WRITTEN REPRESENTATION ON BEHALF OF NORFOLK WILDLIFE TRUST

Application by East Pye Solar Limited for the East Pye Solar Development Consent Order

Planning Inspectorate Reference: EN0110014

Figure 8.3 - Non-Statutory Designated Sites within 2km
 Sheet 2 of 6
 Revision A

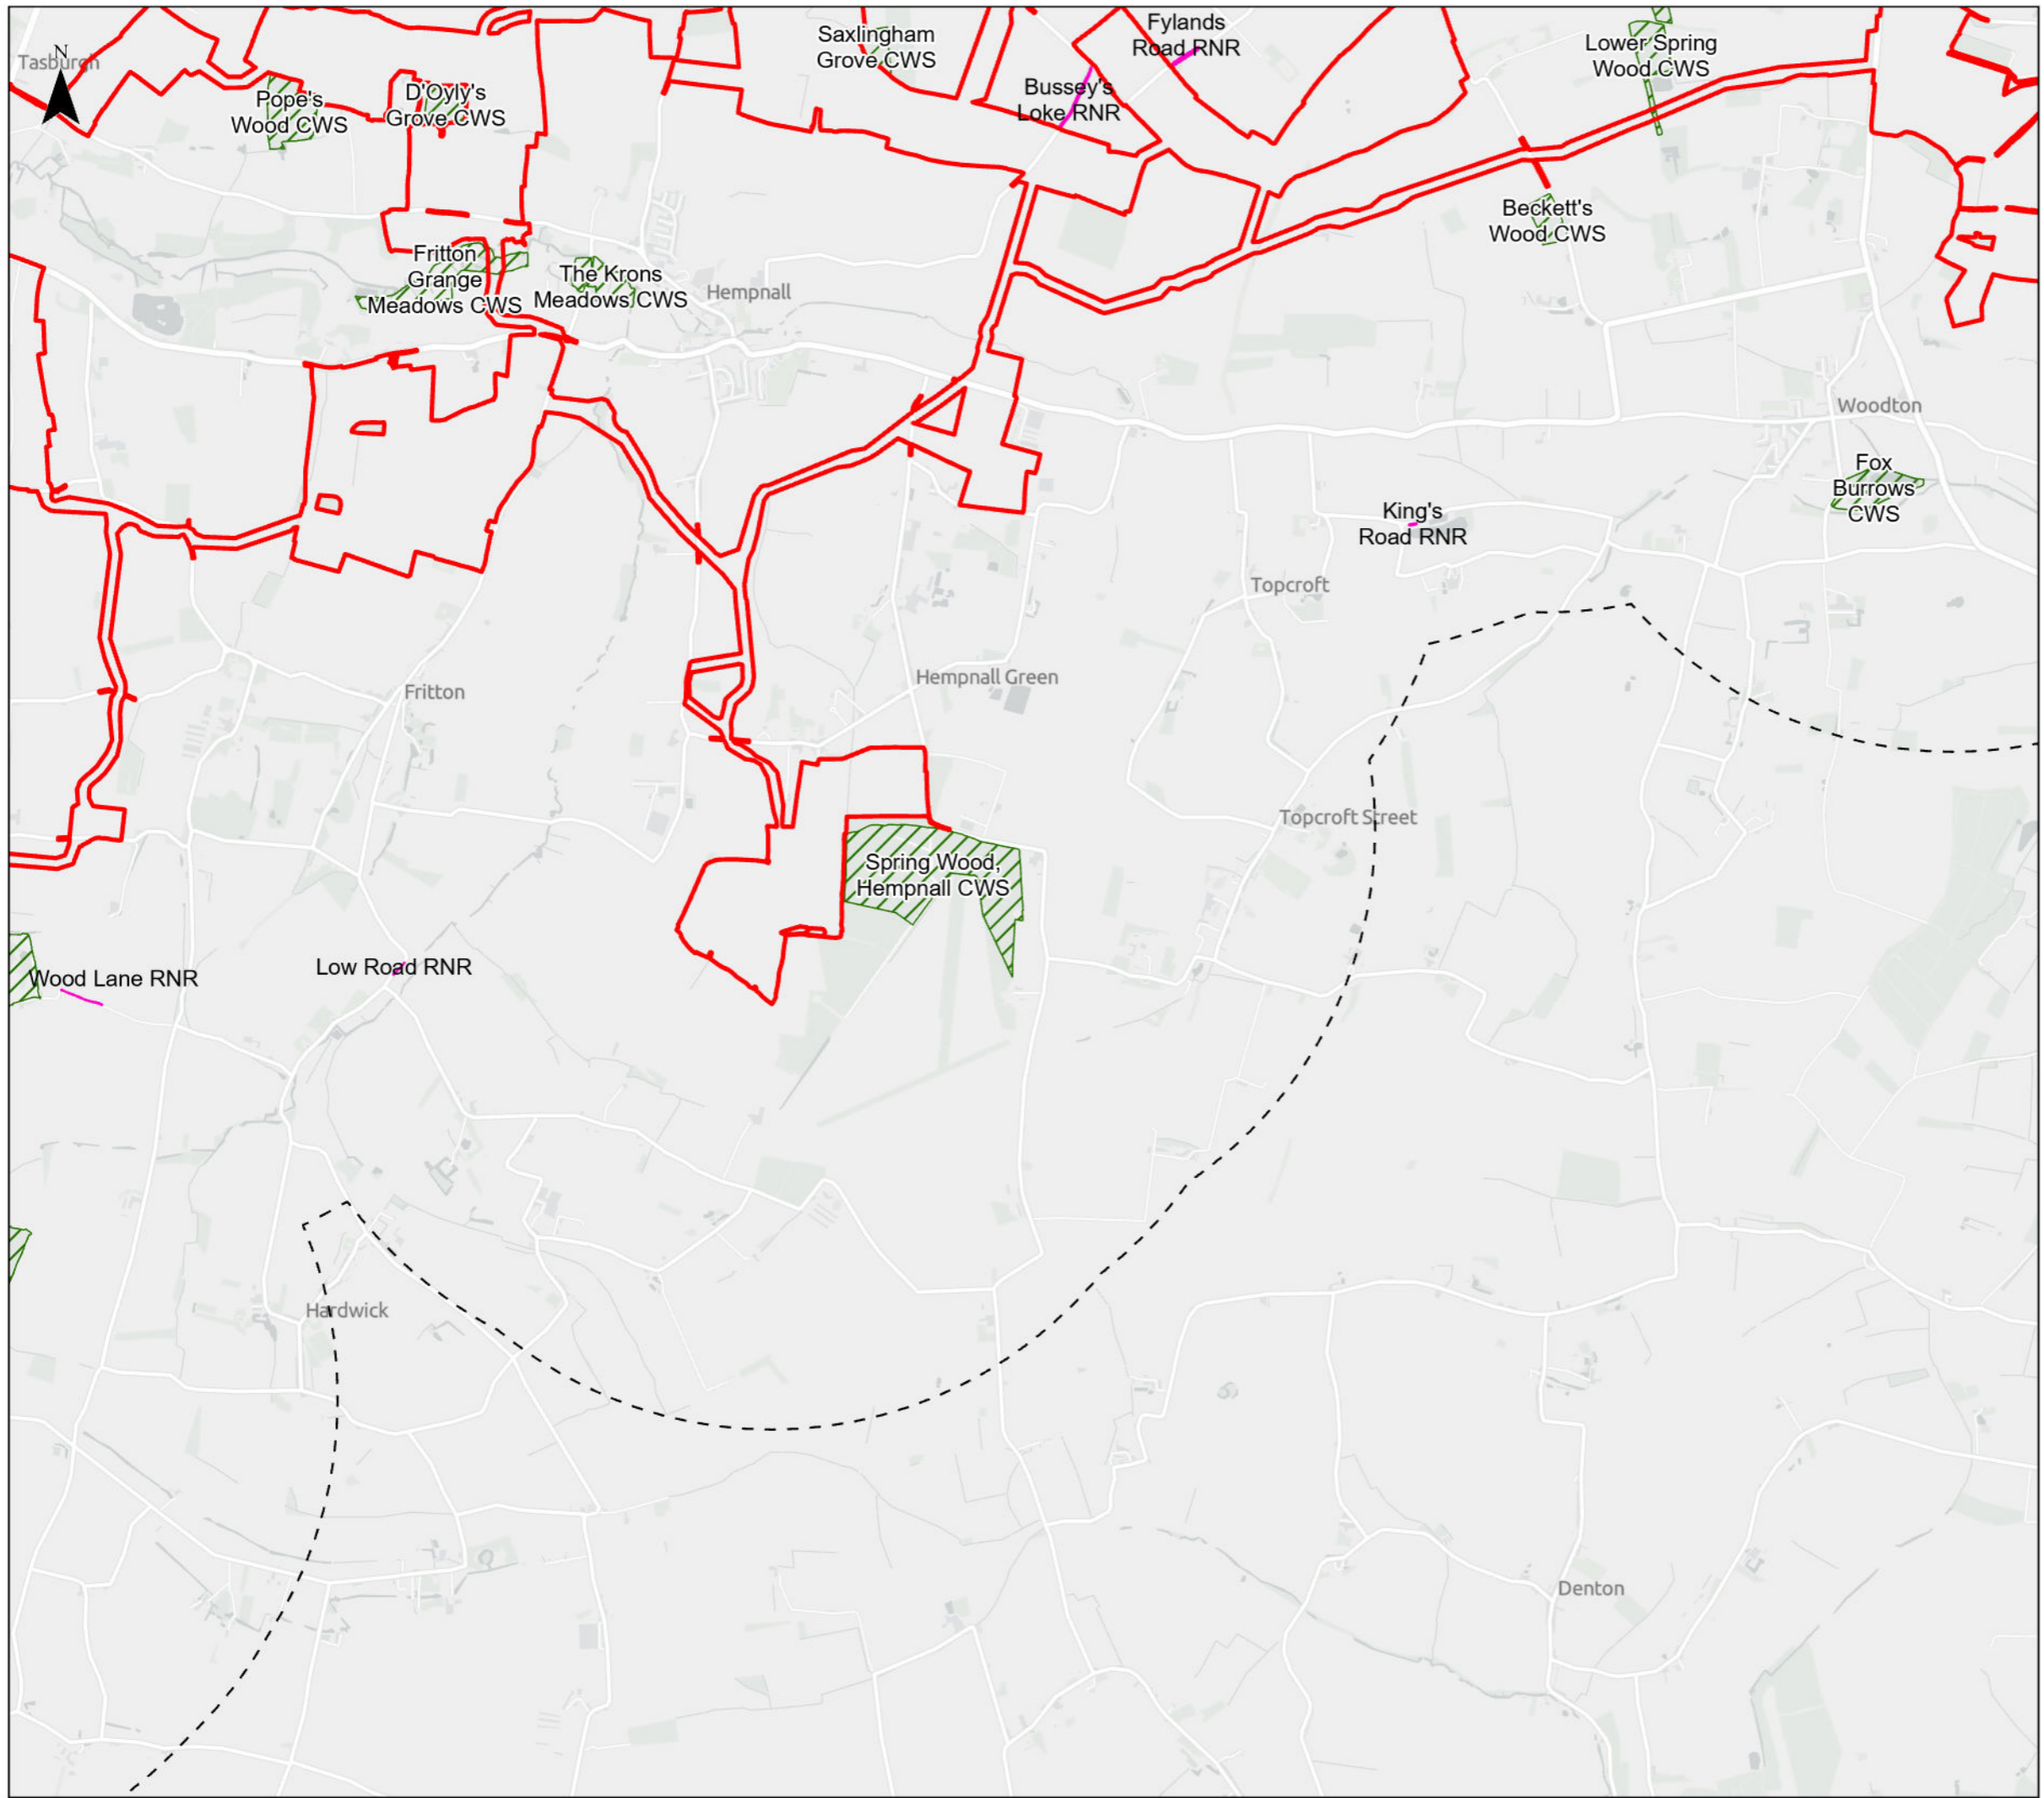
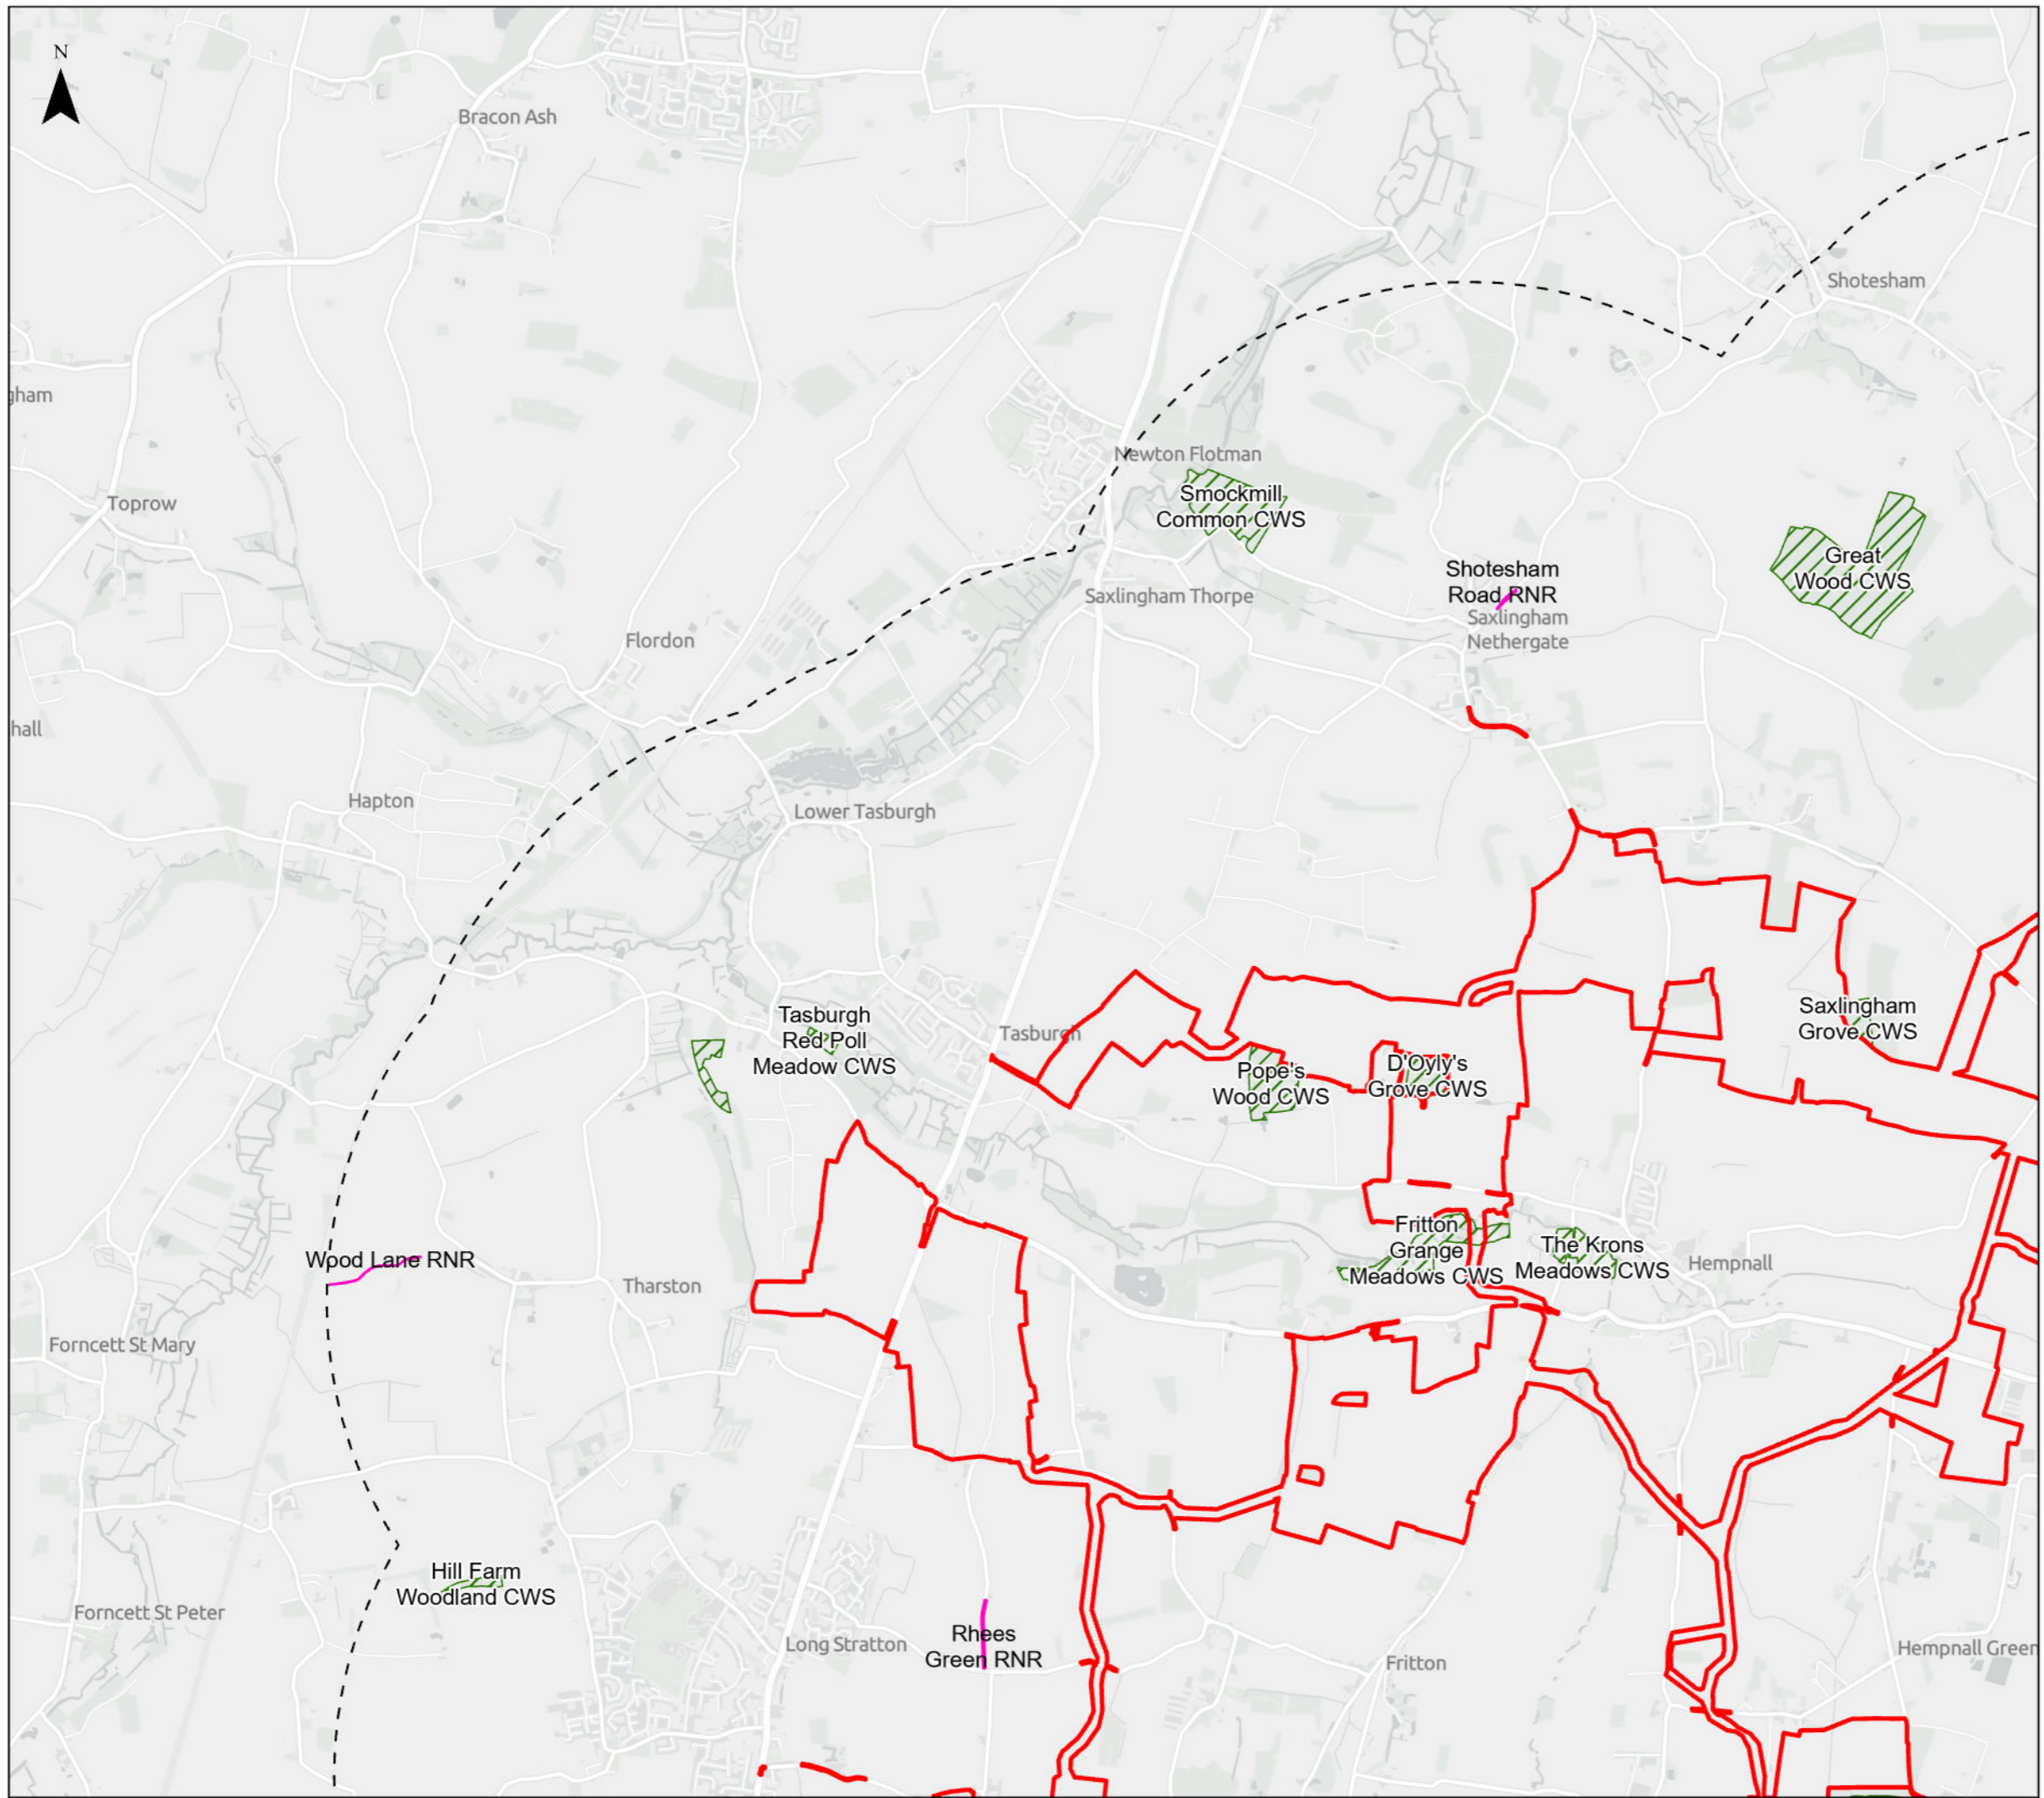
County Wildlife Sites represent an essential component of Norfolk's ecological network and often provide important habitat for priority species outside nationally designated sites. As outlined in paragraph 8.6.7 (ES Chap 8), the Order Limits include parts of two CWSs; Lower Spring Wood CWS (within CR9), and Fritton

Grange Meadows CWS (within CR7), and are adjacent/in the immediate vicinity of several others. The Order Limits also include or adjoin several Roadside Nature Reserves (RNRs), including Bussey's Loke RNR (Sub-Site 7G), Market Lane RNR (Sub-Site 8A), Parkers Lane RNR (Area 1) (CRC4), and Parkers Lane RNR (Area 2) (CRC4). Both direct and indirect impacts on wildlife sites and associated habitat networks must be avoided.
